**From:** Hornby, Mark [Mark.Hornby@lancashire.gov.uk]  
**Sent:** 04 December 2012 14:28  
**To:** Graeme Thorpe  
**Subject:** FW: Consultation on planning application 3/2012/0972 Shays Farm, Tosside  
Graeme

The sight line to the south along Dugdale Lane at the farm access is currently very poor due to the frontage stone wall. Although the speed limit is 60mph the carriageway width, road alignment and low traffic levels mean a visibility splay of 2m x 50m to the centre of the carriageway would be appropriate in the circumstances. This could be achieved by rebuilding the wall from the existing field gatepost in a straight line for 25 metres to the existing wall line. This would in my view be adequate for the highway conditions and the likely increase in turning traffic from the proposed holiday cottages. I understand from the applicant's agent that they have control of the land required and are prepared to undertake the work.

S I T E P L A N A S P R O P O S E D

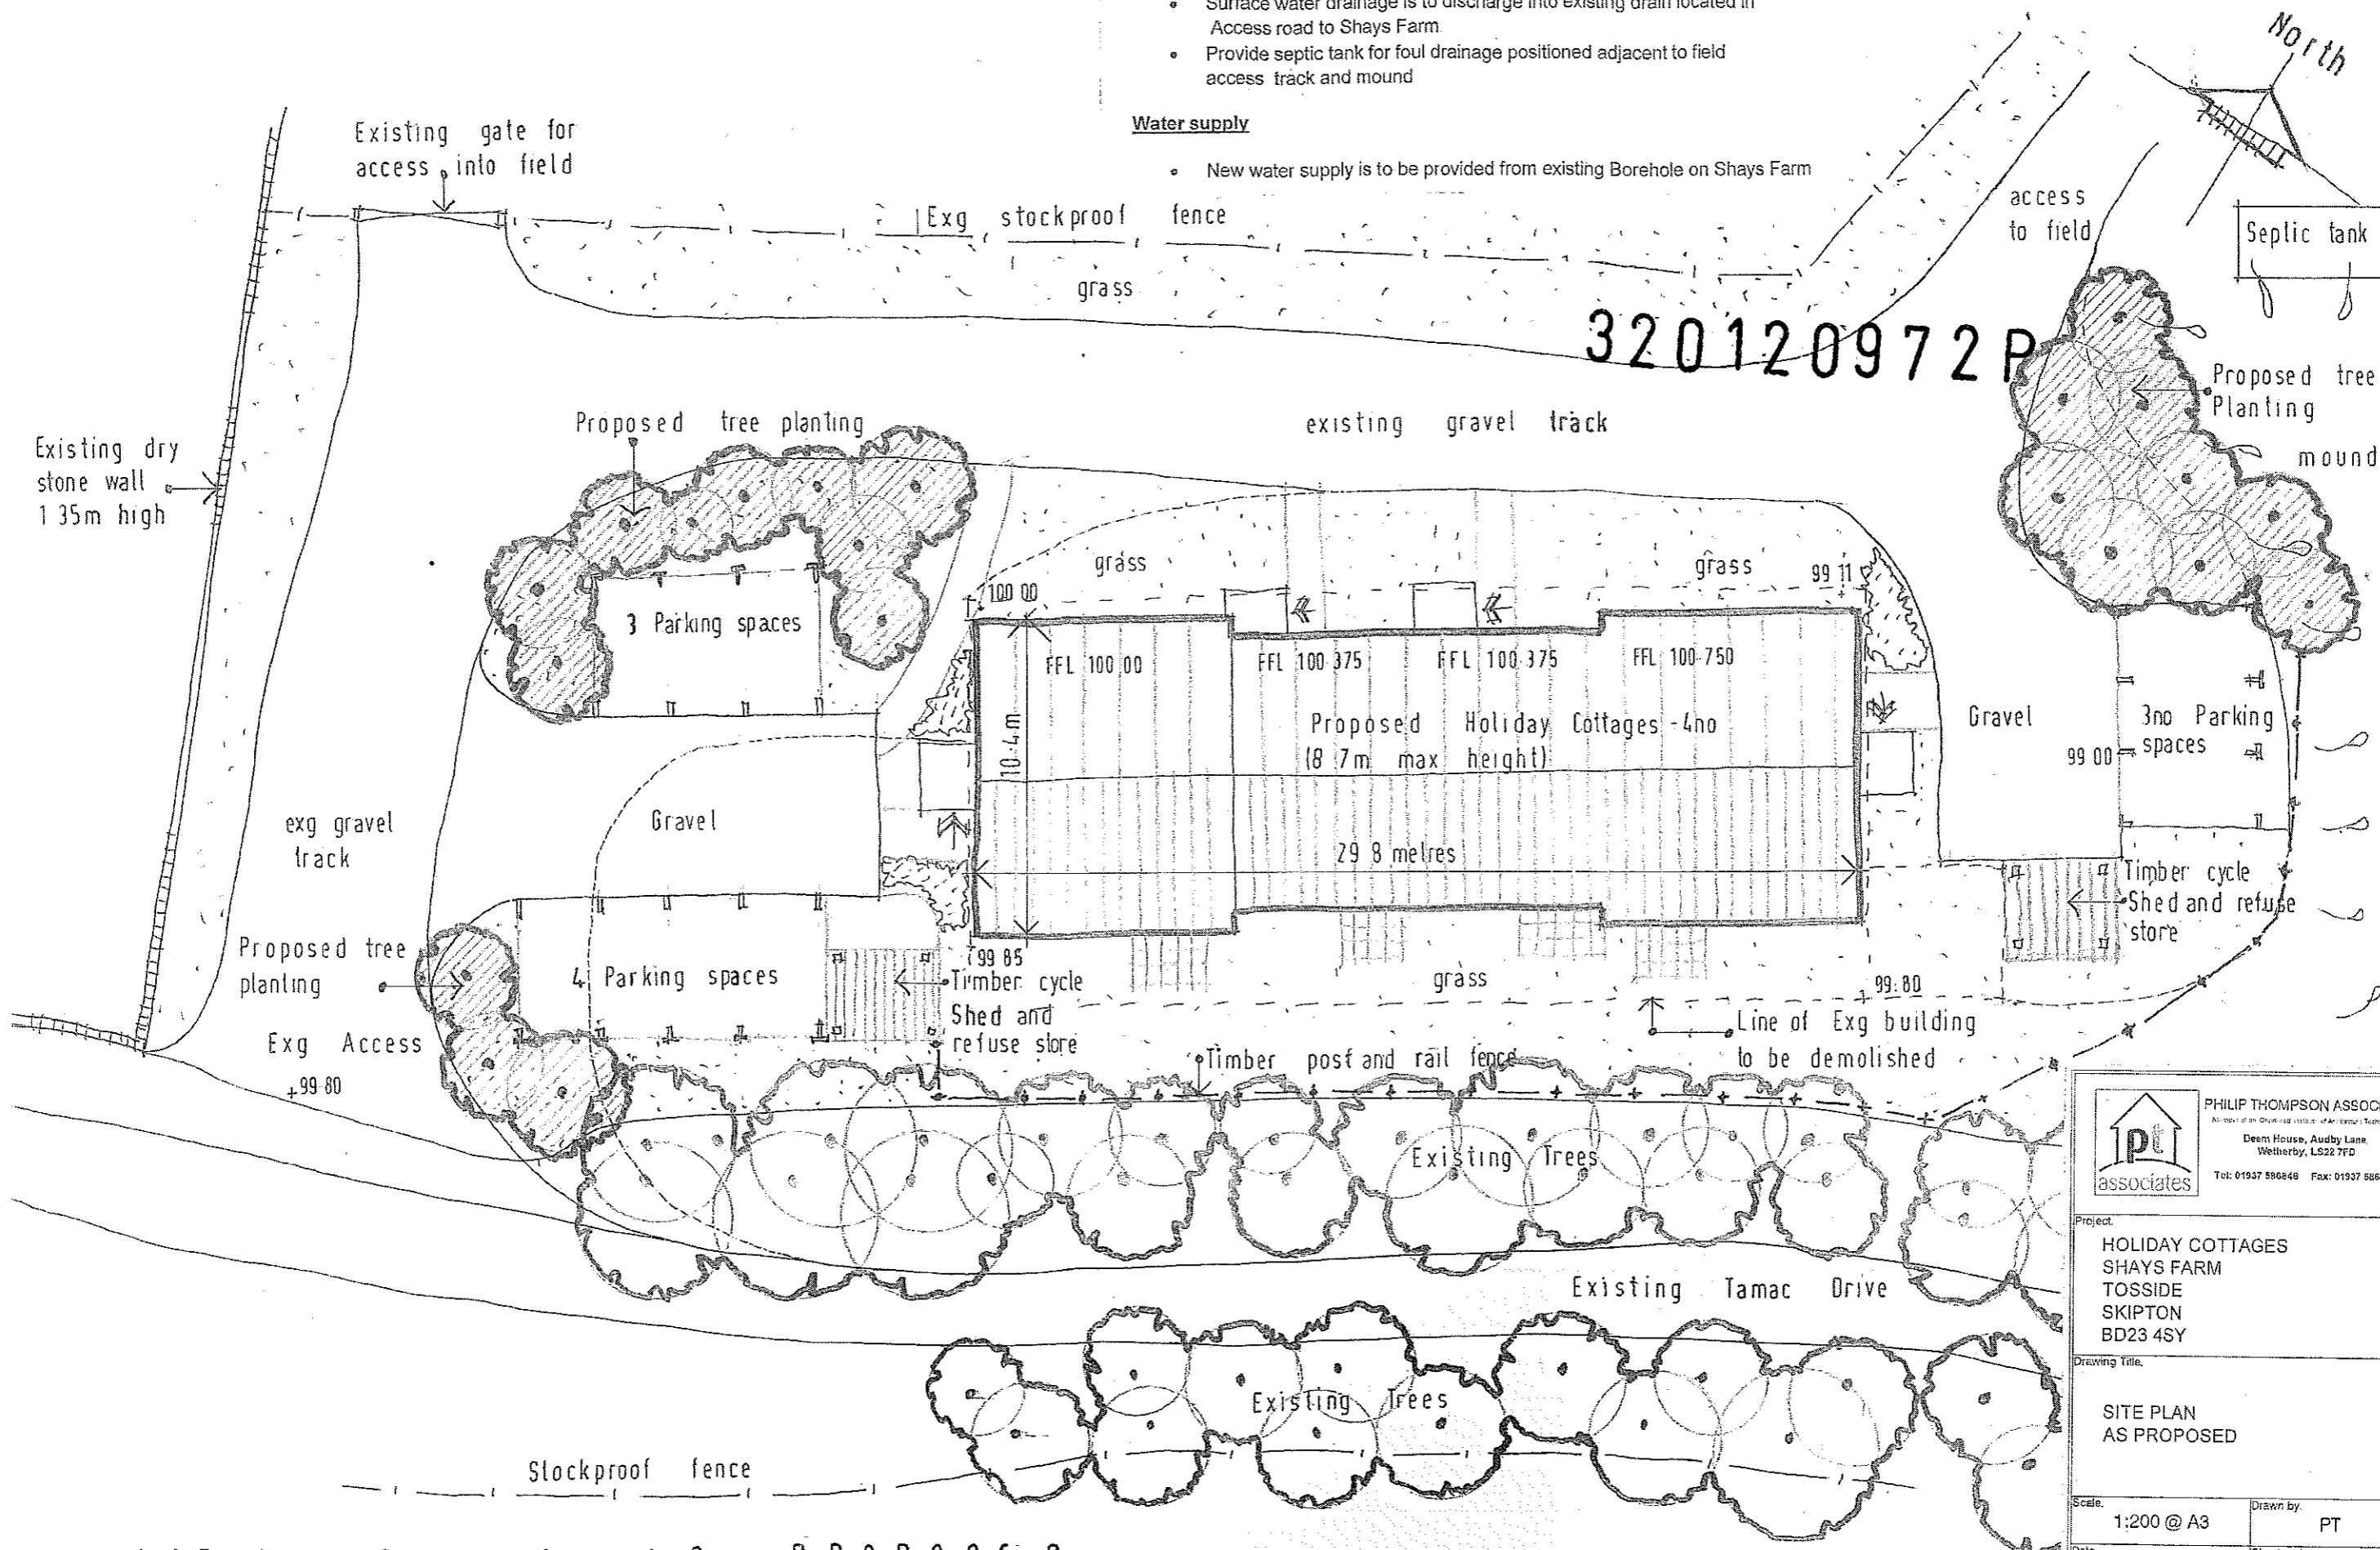
The existing stone wall to the south of the farm access track along Dugdale Lane shall be rebuilt in a straight line for 25 metres from the existing field gatepost to the existing wall line before any further development takes place within the site. Reason: To improve visibility at the access point in the interests of highway safety.
